**Consultation Response from KC,
Lead Local Flood Authority**

2023/93539 Land adj, Ledgard Bridge Mill, Back Station Road, Mirfield, WF14 8NZ

Date Responded: 4th January 2024

Project: Proposed residential scheme at Ledgard Bridge, Mirfield
 Client: Birks Executive Homes Ltd, Cawthorne, Bamsley S75 4EJ
 Dwg Title: 170012_Site Plan
 Scale: 1:200 @ A0
 Date: Jan 22

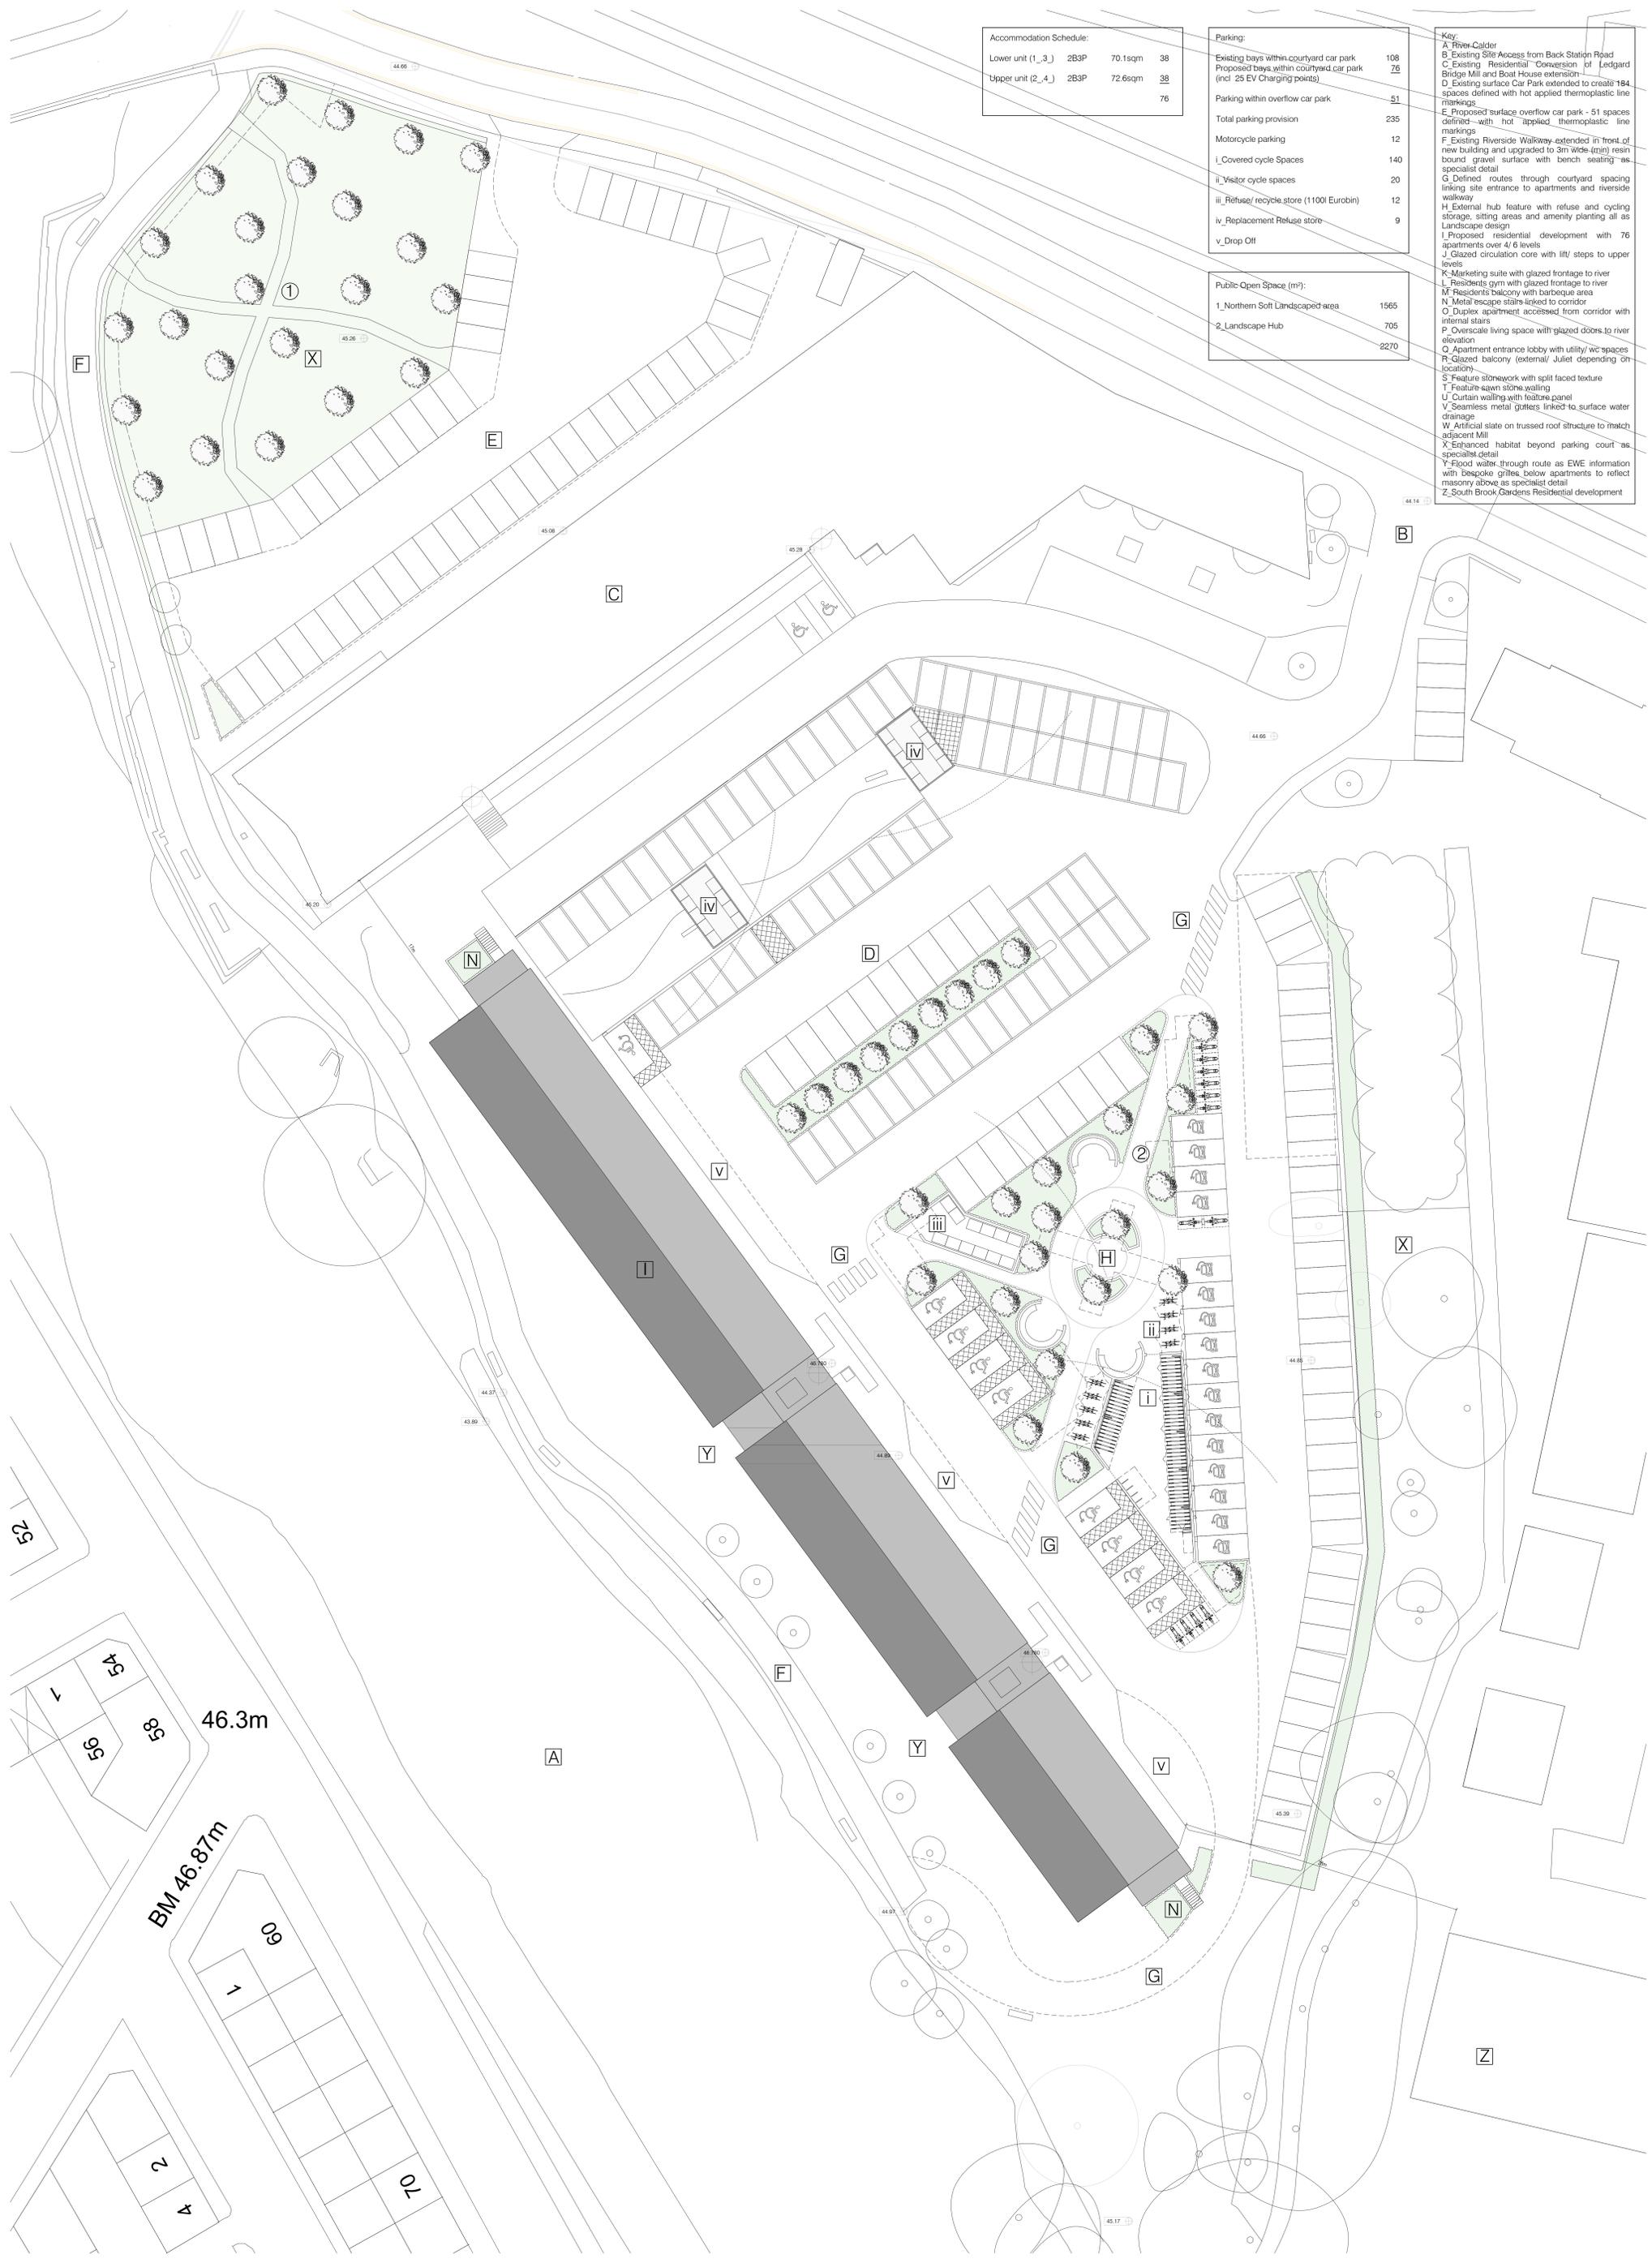
- The nature of flooding both within the site and its immediate vicinity means there is no safe access and egress available (evacuation plan) in storm events which will put a reliance on, and as a result, place emergency services at risk. This is unacceptable in our opinion. The Environment Agency do not comment on flood and evacuations plans.
